Planning, Regeneration and Development Service
Council Offices
White Cliffs Business Park
Dover
Kent CT16 3PJ

Contact: Miss Morgan
E-mail: Rachel.Morgan@dover.gov.uk
Our ref: PE/23/00019
Date: 09/05/2023

Proposal: Change of use of ATCOST barn from agricultural to dwelling
Location: Minnis Farm, Minnis Way, Worth

Drawing Description  
**Proposed Front & Side Elevations  
 Barn 1**

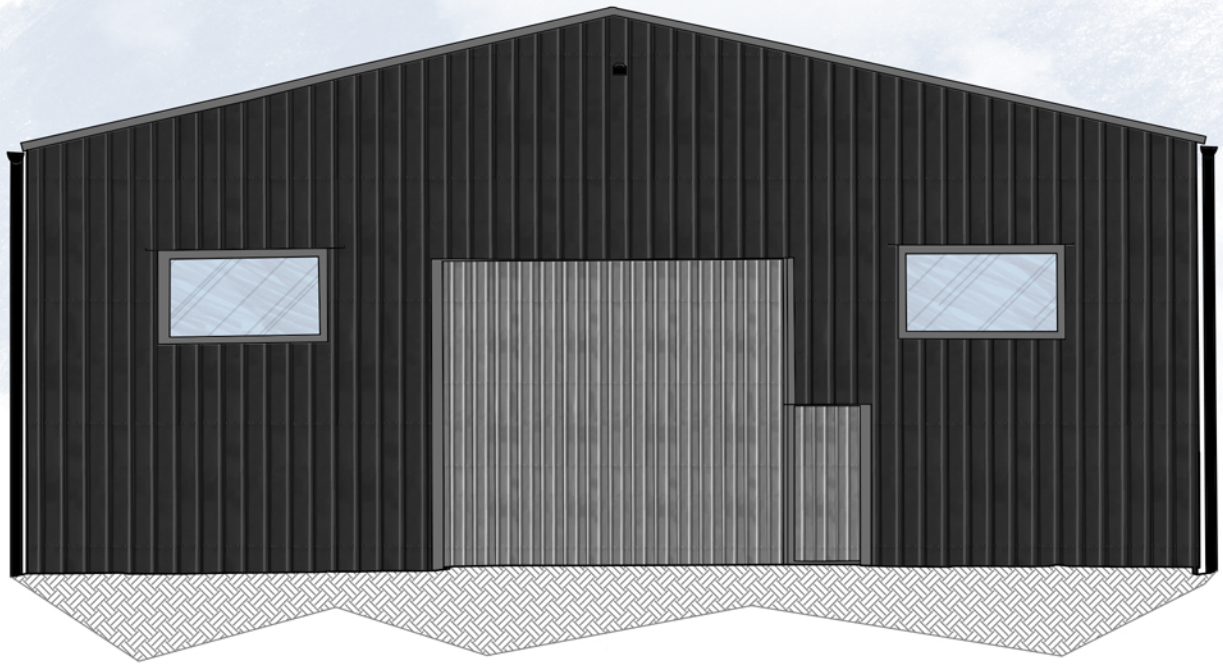
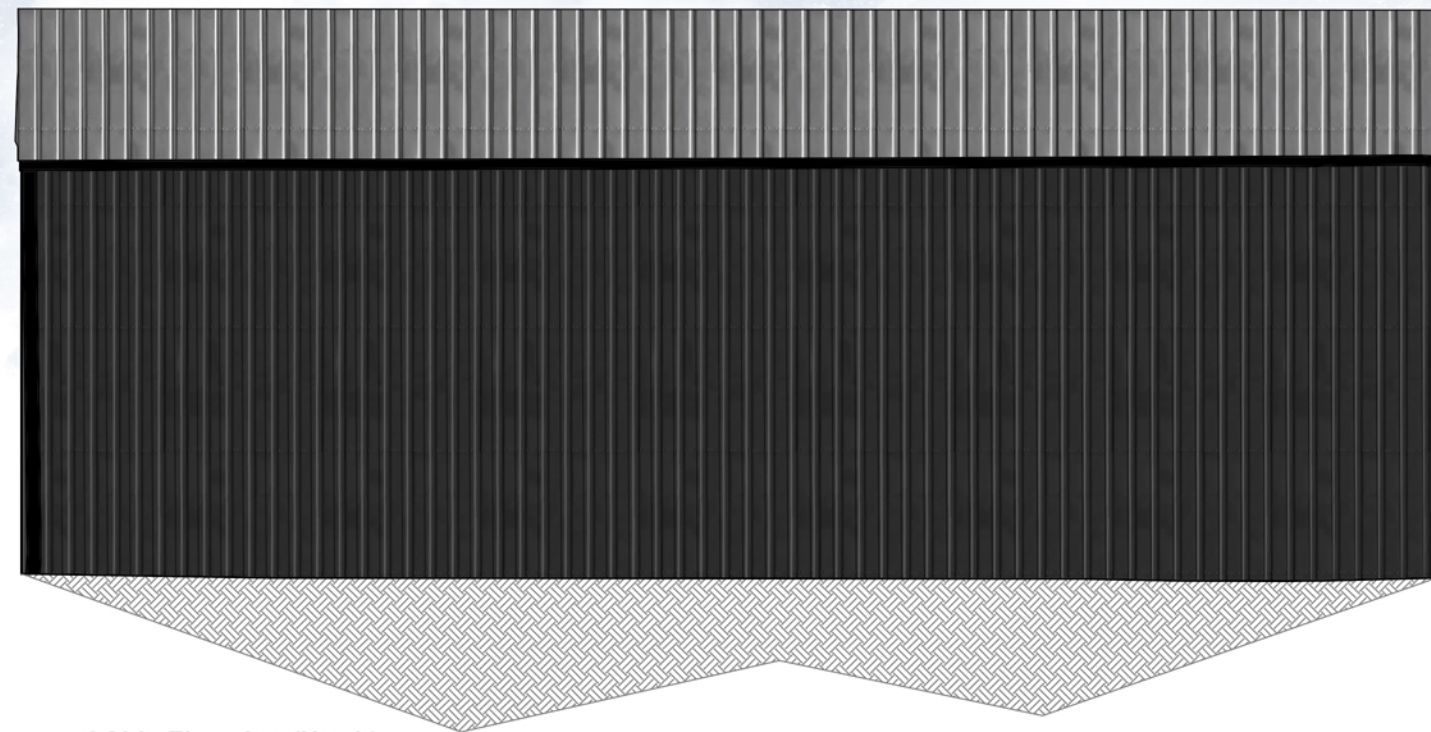
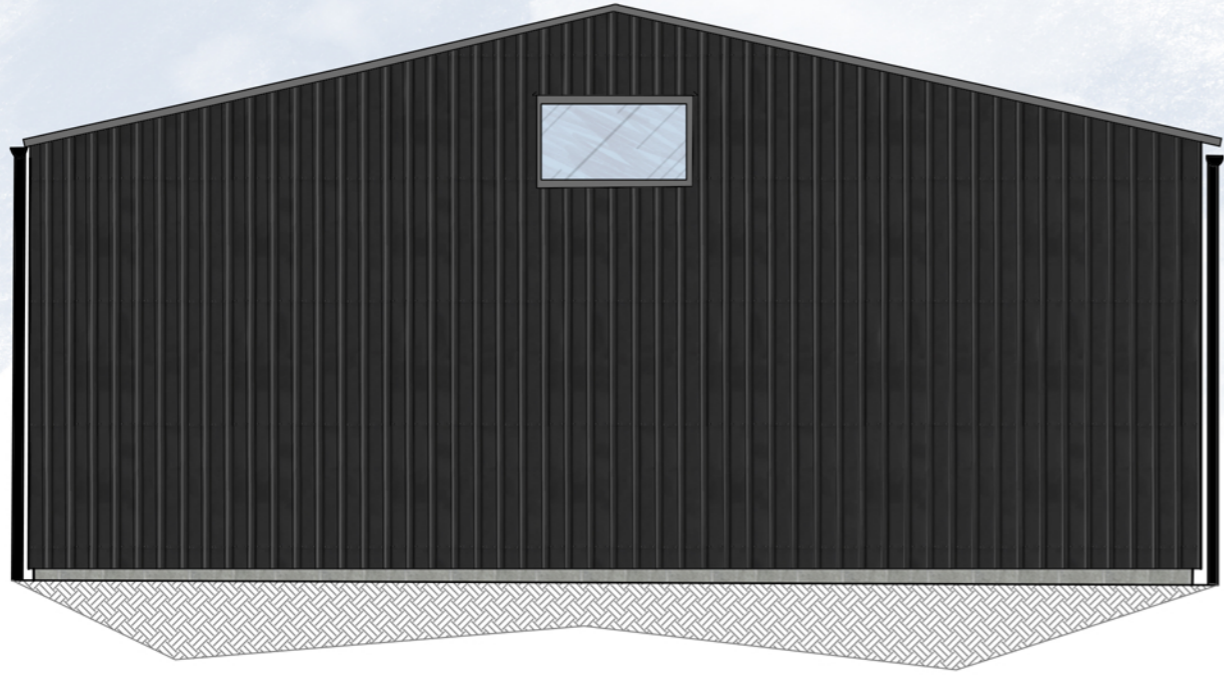
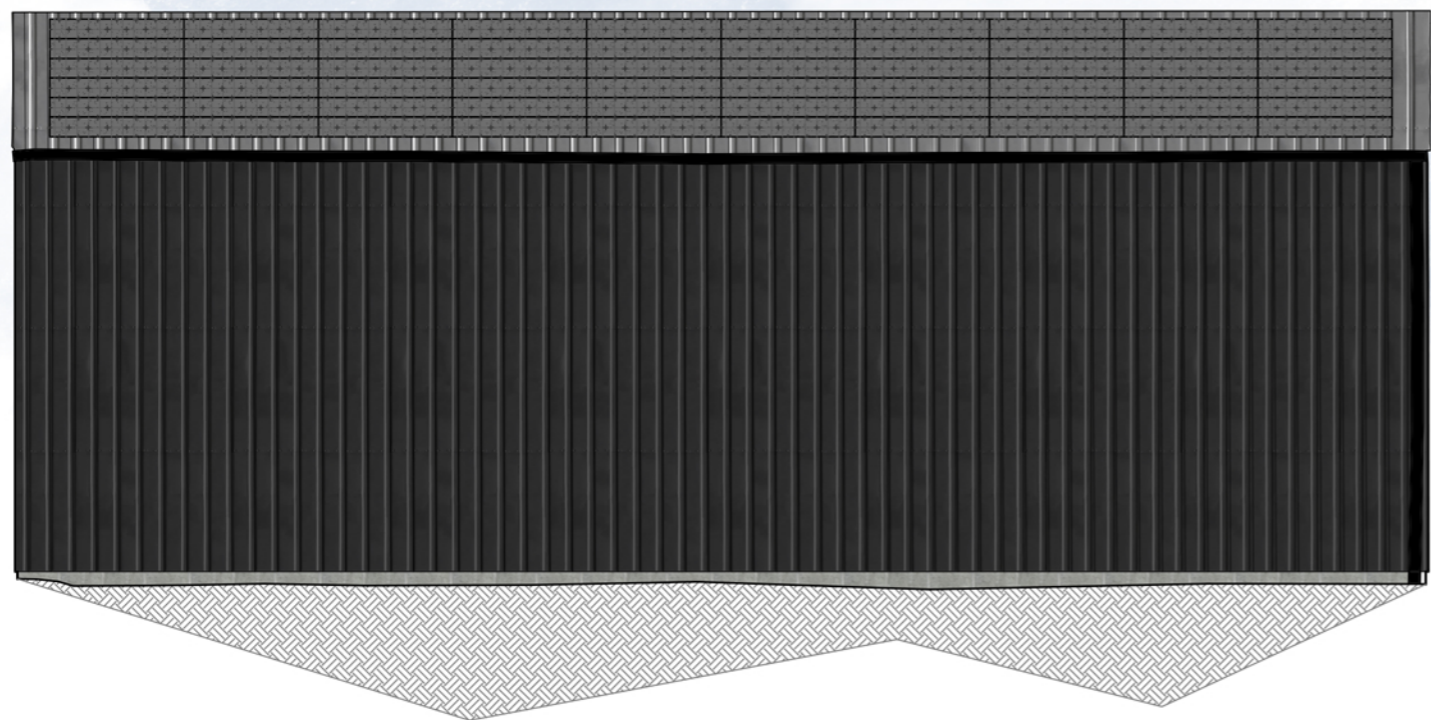
There are at least four other barns at the site, one of which (barn 1) has obtained prior approval under Class Q (enabling it to change to a residential use). This is proposed to be retained to form a garage and would be re-clad in natural black boarding.

The design and access statement sets out that it is proposed to change the cladding to barn 1 (required to allow for storage and act as a garage for the new dwelling). Natural black boarding is proposed to reduce its visual impact, and would tie in with the proposed cladding to the larger barn.
